Gunlake Quarry Continuation Project

Responses to information requests

Prepared for Gunlake Quarries Pty Ltd

August 2022

## Culvert widening concept drawing

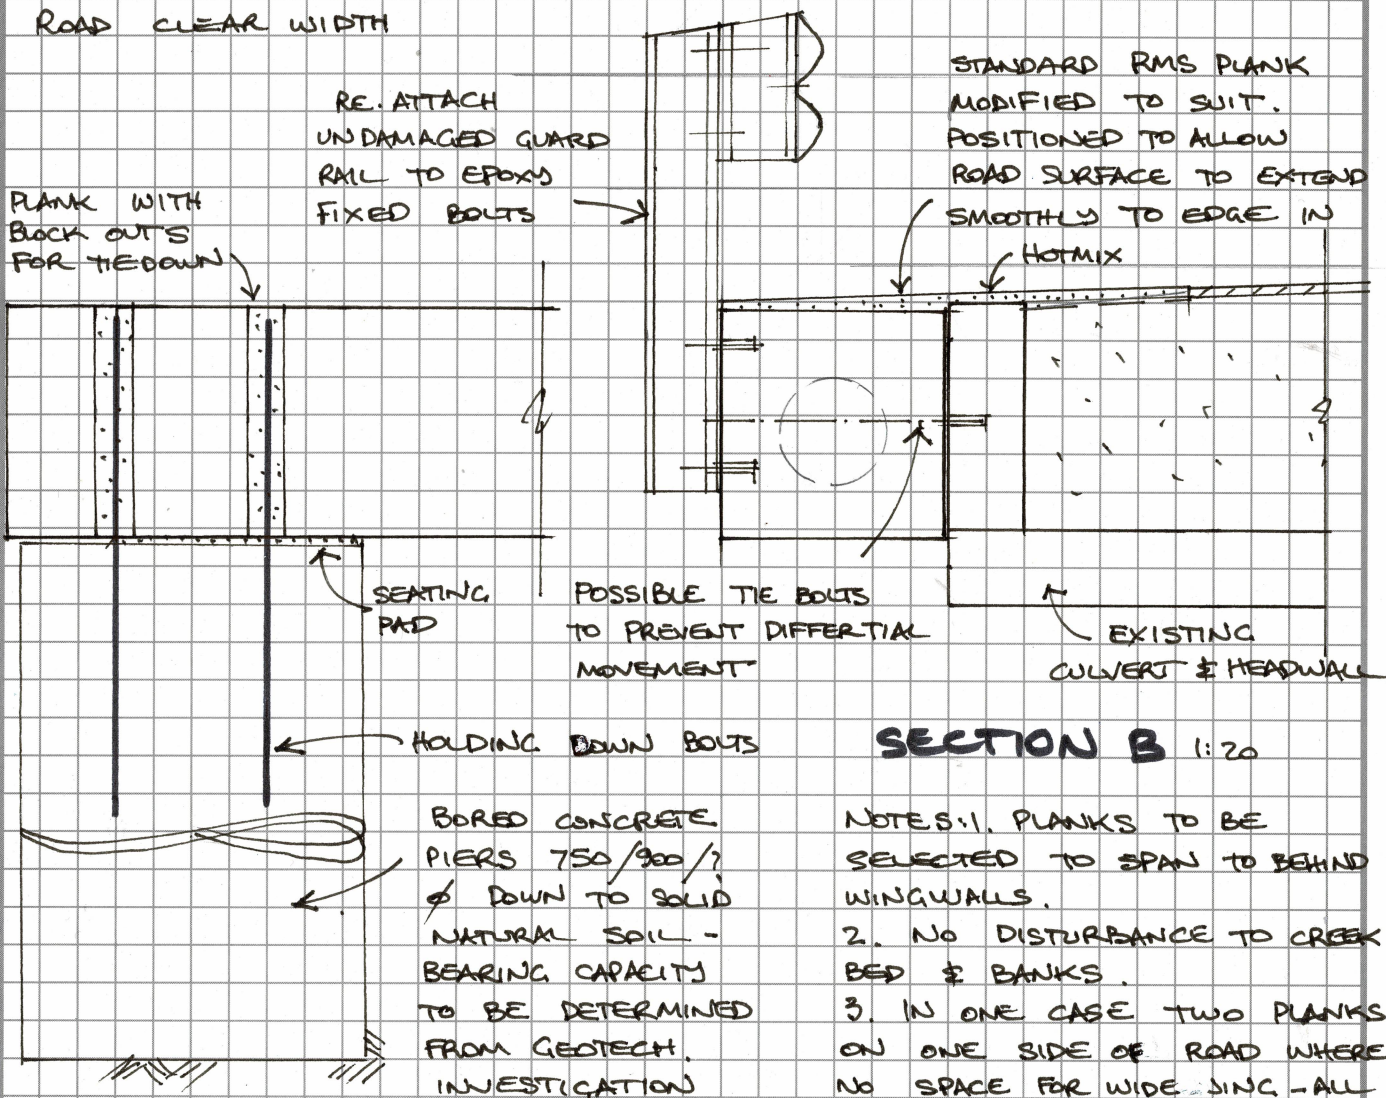
Gunlake have committed to widening Culverts A to E. This approach is supported in Section 5.2 of the independent review commissioned by DPE (Bitzios 2022) that recommends that widening of Culverts A–E (not Culvert F) is imposed as a consent condition. However in Section 5.2, Bitzios (2022) also recommend that "[f]urther justification should be provided by the applicant as to why the WCLT [wide centre line treatment] is not extended through Culvert F".

Council request that DPE impose a condition requiring Culverts A–F to be widened.

It is proposed to widen Culverts A to E (culvert locations are shown in Submissions Report Figure 3.1 which is replicated in Figure 2.3 below) as part of the Gunlake Quarry Continuation Project to allow the WCLT to be extended across these culverts. The additional sections of WCLT are described below along with an explanation of why there would be negligible benefit from widening Culvert F.

It is proposed to widen Culverts A–E along the Primary Transport Route (see Section 3.2 of the Submissions Report) to allow the WCLT to continue across these culverts (Table 2.1). Widening the culverts will provide an additional 700 m WCLT along the Primary Transport Route.

Culverts A–E will be installed and the WCLT extended prior to Gunlake Quarry truck numbers exceeding those approved under LEC Approval 2017/108663.

As the WCLT does not extend up the steep incline on Ambrose Road, widening of Culvert F would only allow the WCLT to be extended across the culvert itself which would be of little benefit. This position is supported by Bitzios (2022) which states in Table 4.3:

Figure 5.9 Future (2051) cumulative traffic volumes (ie Gunlake Quarry traffic plus all non-Gunlake Quarry traffic)

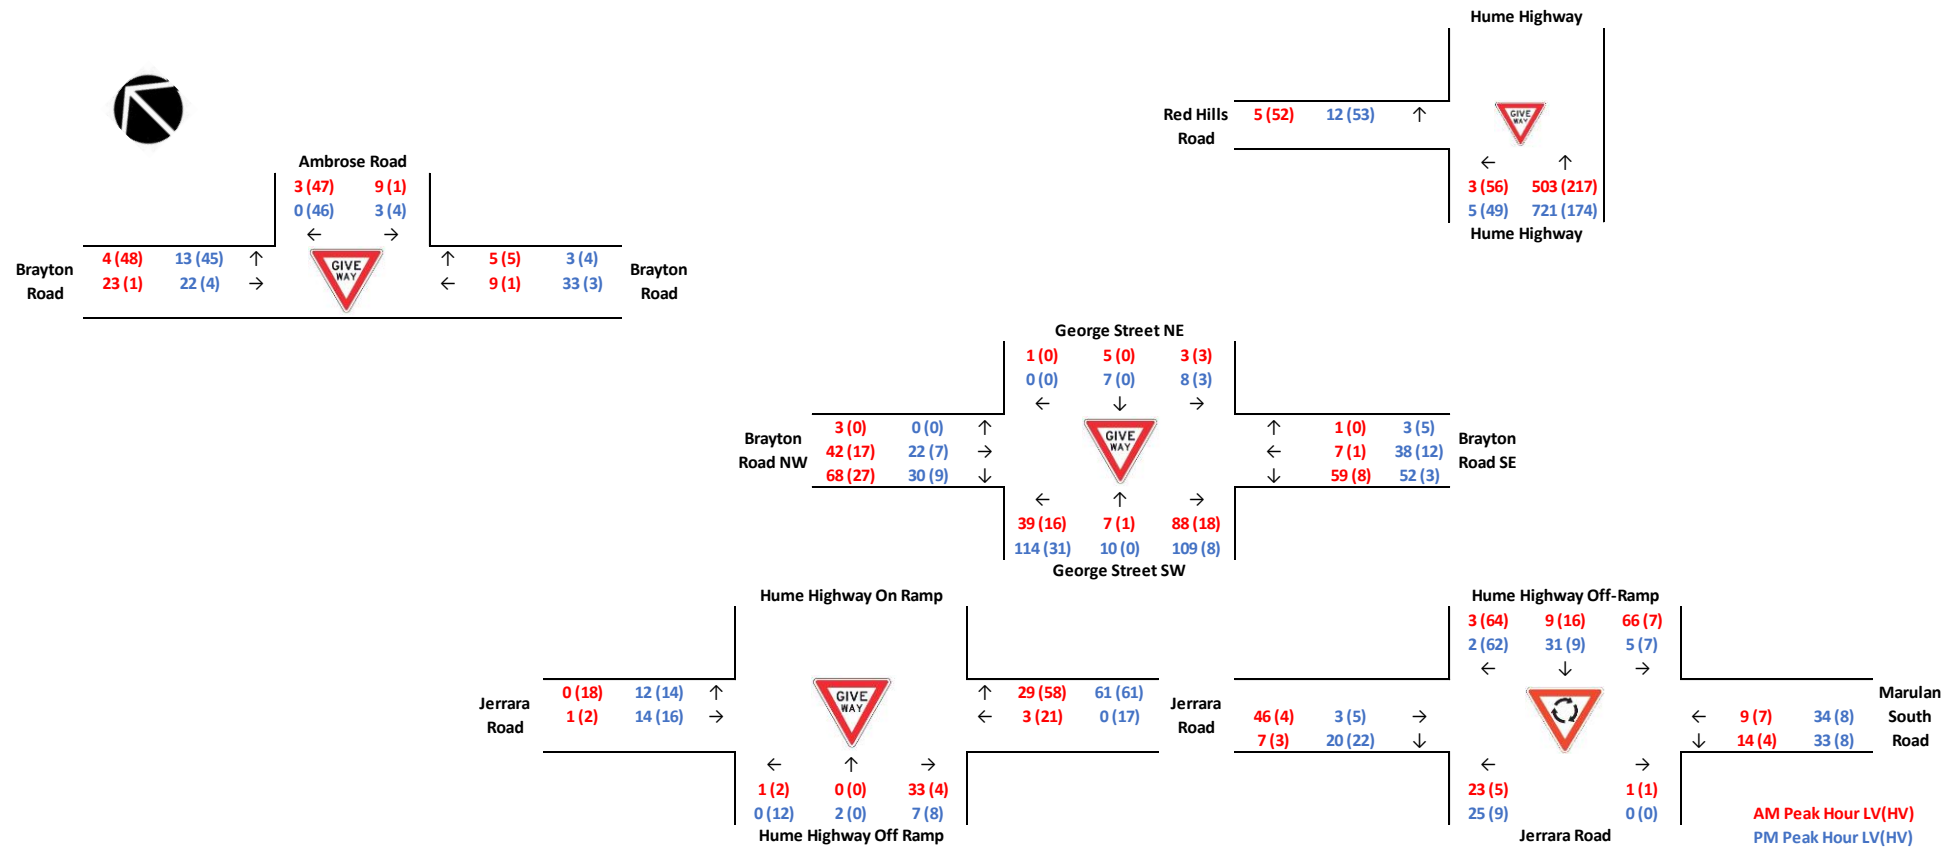
Bitzios (2022) recommend an intersection capacity assessment of the Brayton Road/quarry access road intersection.

Intersection capacity assessments using SIDRA modelling for the key intersections of public roads are presented in the *Gunlake Quarry Continuation Project Traffic Impact Assessment* (TIA) (EMM 2021b, provided in EIS Appendix F.1). This did not include the Brayton Road/private quarry access road intersection. This intersection has been designed and constructed so that it does not limit, delay or impede traffic flow on Brayton Road.

The TIA is based on a maximum of 40 trucks dispatched from the quarry during a peak hour (TIA Section 4.4.2), ie an average of one outbound truck every 1.5 minutes and one inbound truck every 1.5 minutes (ie a peak of one movement every 45 seconds was included in the traffic assessments).

The future (2051) cumulative traffic volumes (ie Gunlake Quarry traffic plus all non-Gunlake Quarry traffic) are shown in TIA Figure 5.9. The traffic volumes on Brayton Road between the quarry and the Brayton Road/Ambrose Road intersection are shown in Figure 2.2 below.

There are low non-Gunlake Quarry traffic volumes on this section of Brayton Road. As there are no intersections between the Quarry and Ambrose Road, the traffic volumes shown in Figure 2.2 can be used to determine through traffic at the Brayton Road/quarry access road intersection. For example, it is predicted that there will be 27 light vehicles (4+23) and 9 heavy vehicles (48+1-40) southbound through traffic during the whole of the morning peak hour (about one southbound vehicle every two minutes). Given the low number of movements on each leg of the Brayton Road/private quarry access road intersection, the intersection SIDRA modelling was not warranted for this intersection as it is clear that this has ample capacity.
